RE: MOD 16 MP09_0066 THOMAS STREET CAR PARK SITE

The following provides a response to the issues raised by the Department and Willoughby Council in relation to the subject MOD application. Please also find amended plans accompanying this correspondence.

L27

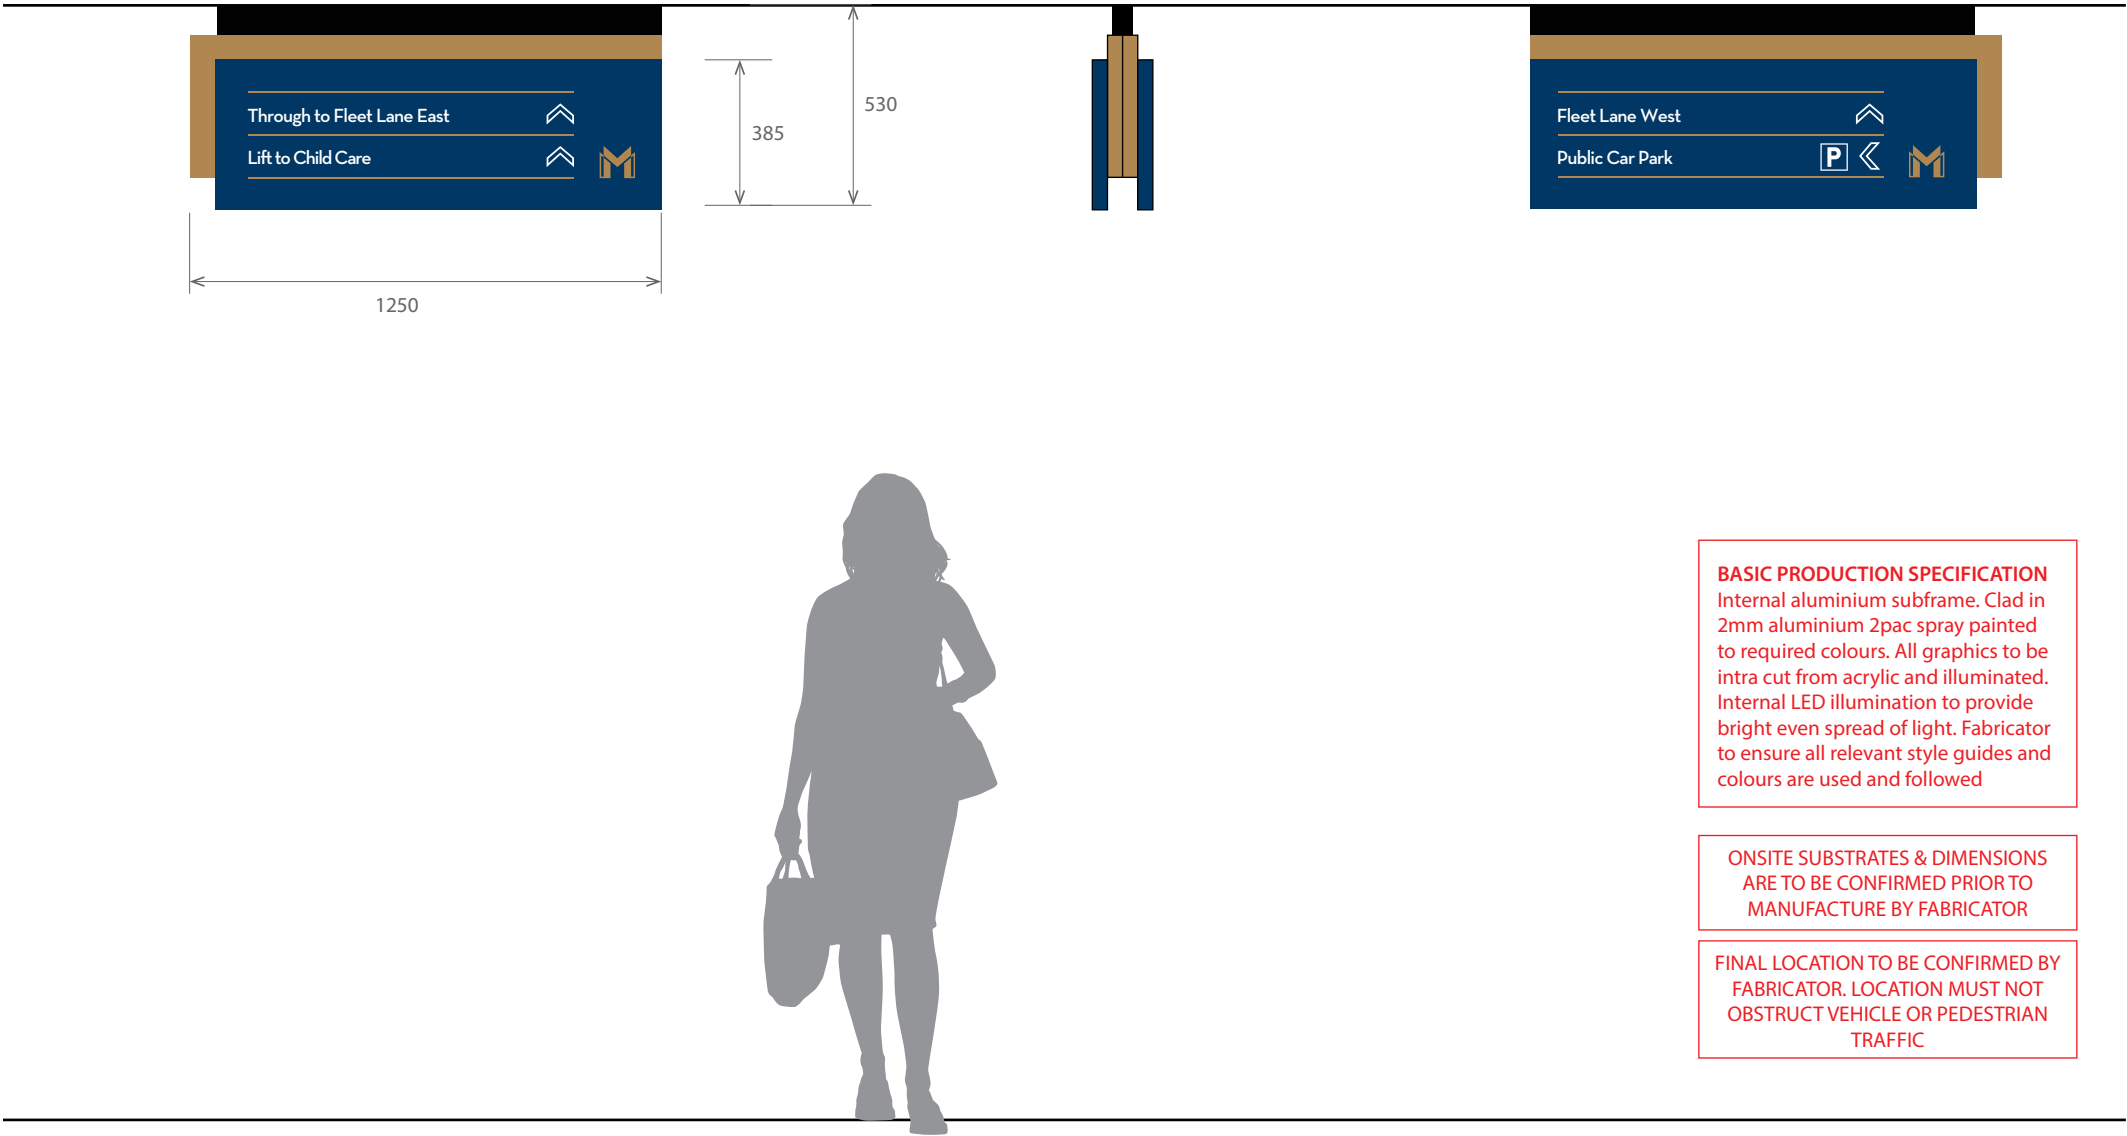
5. *An internal site sign directing pedestrians to the link to Fleet Lane East is required. Council reminds the Department of the many submissions and issues relating to connection for people with disabilities from the public car park to attend the medical practices in the adjacent 12 Thomas Street building where access for people with disabilities is from Fleet Lane East.*

A new sign at L27 has been added that provides directions to Fleet Lane East.
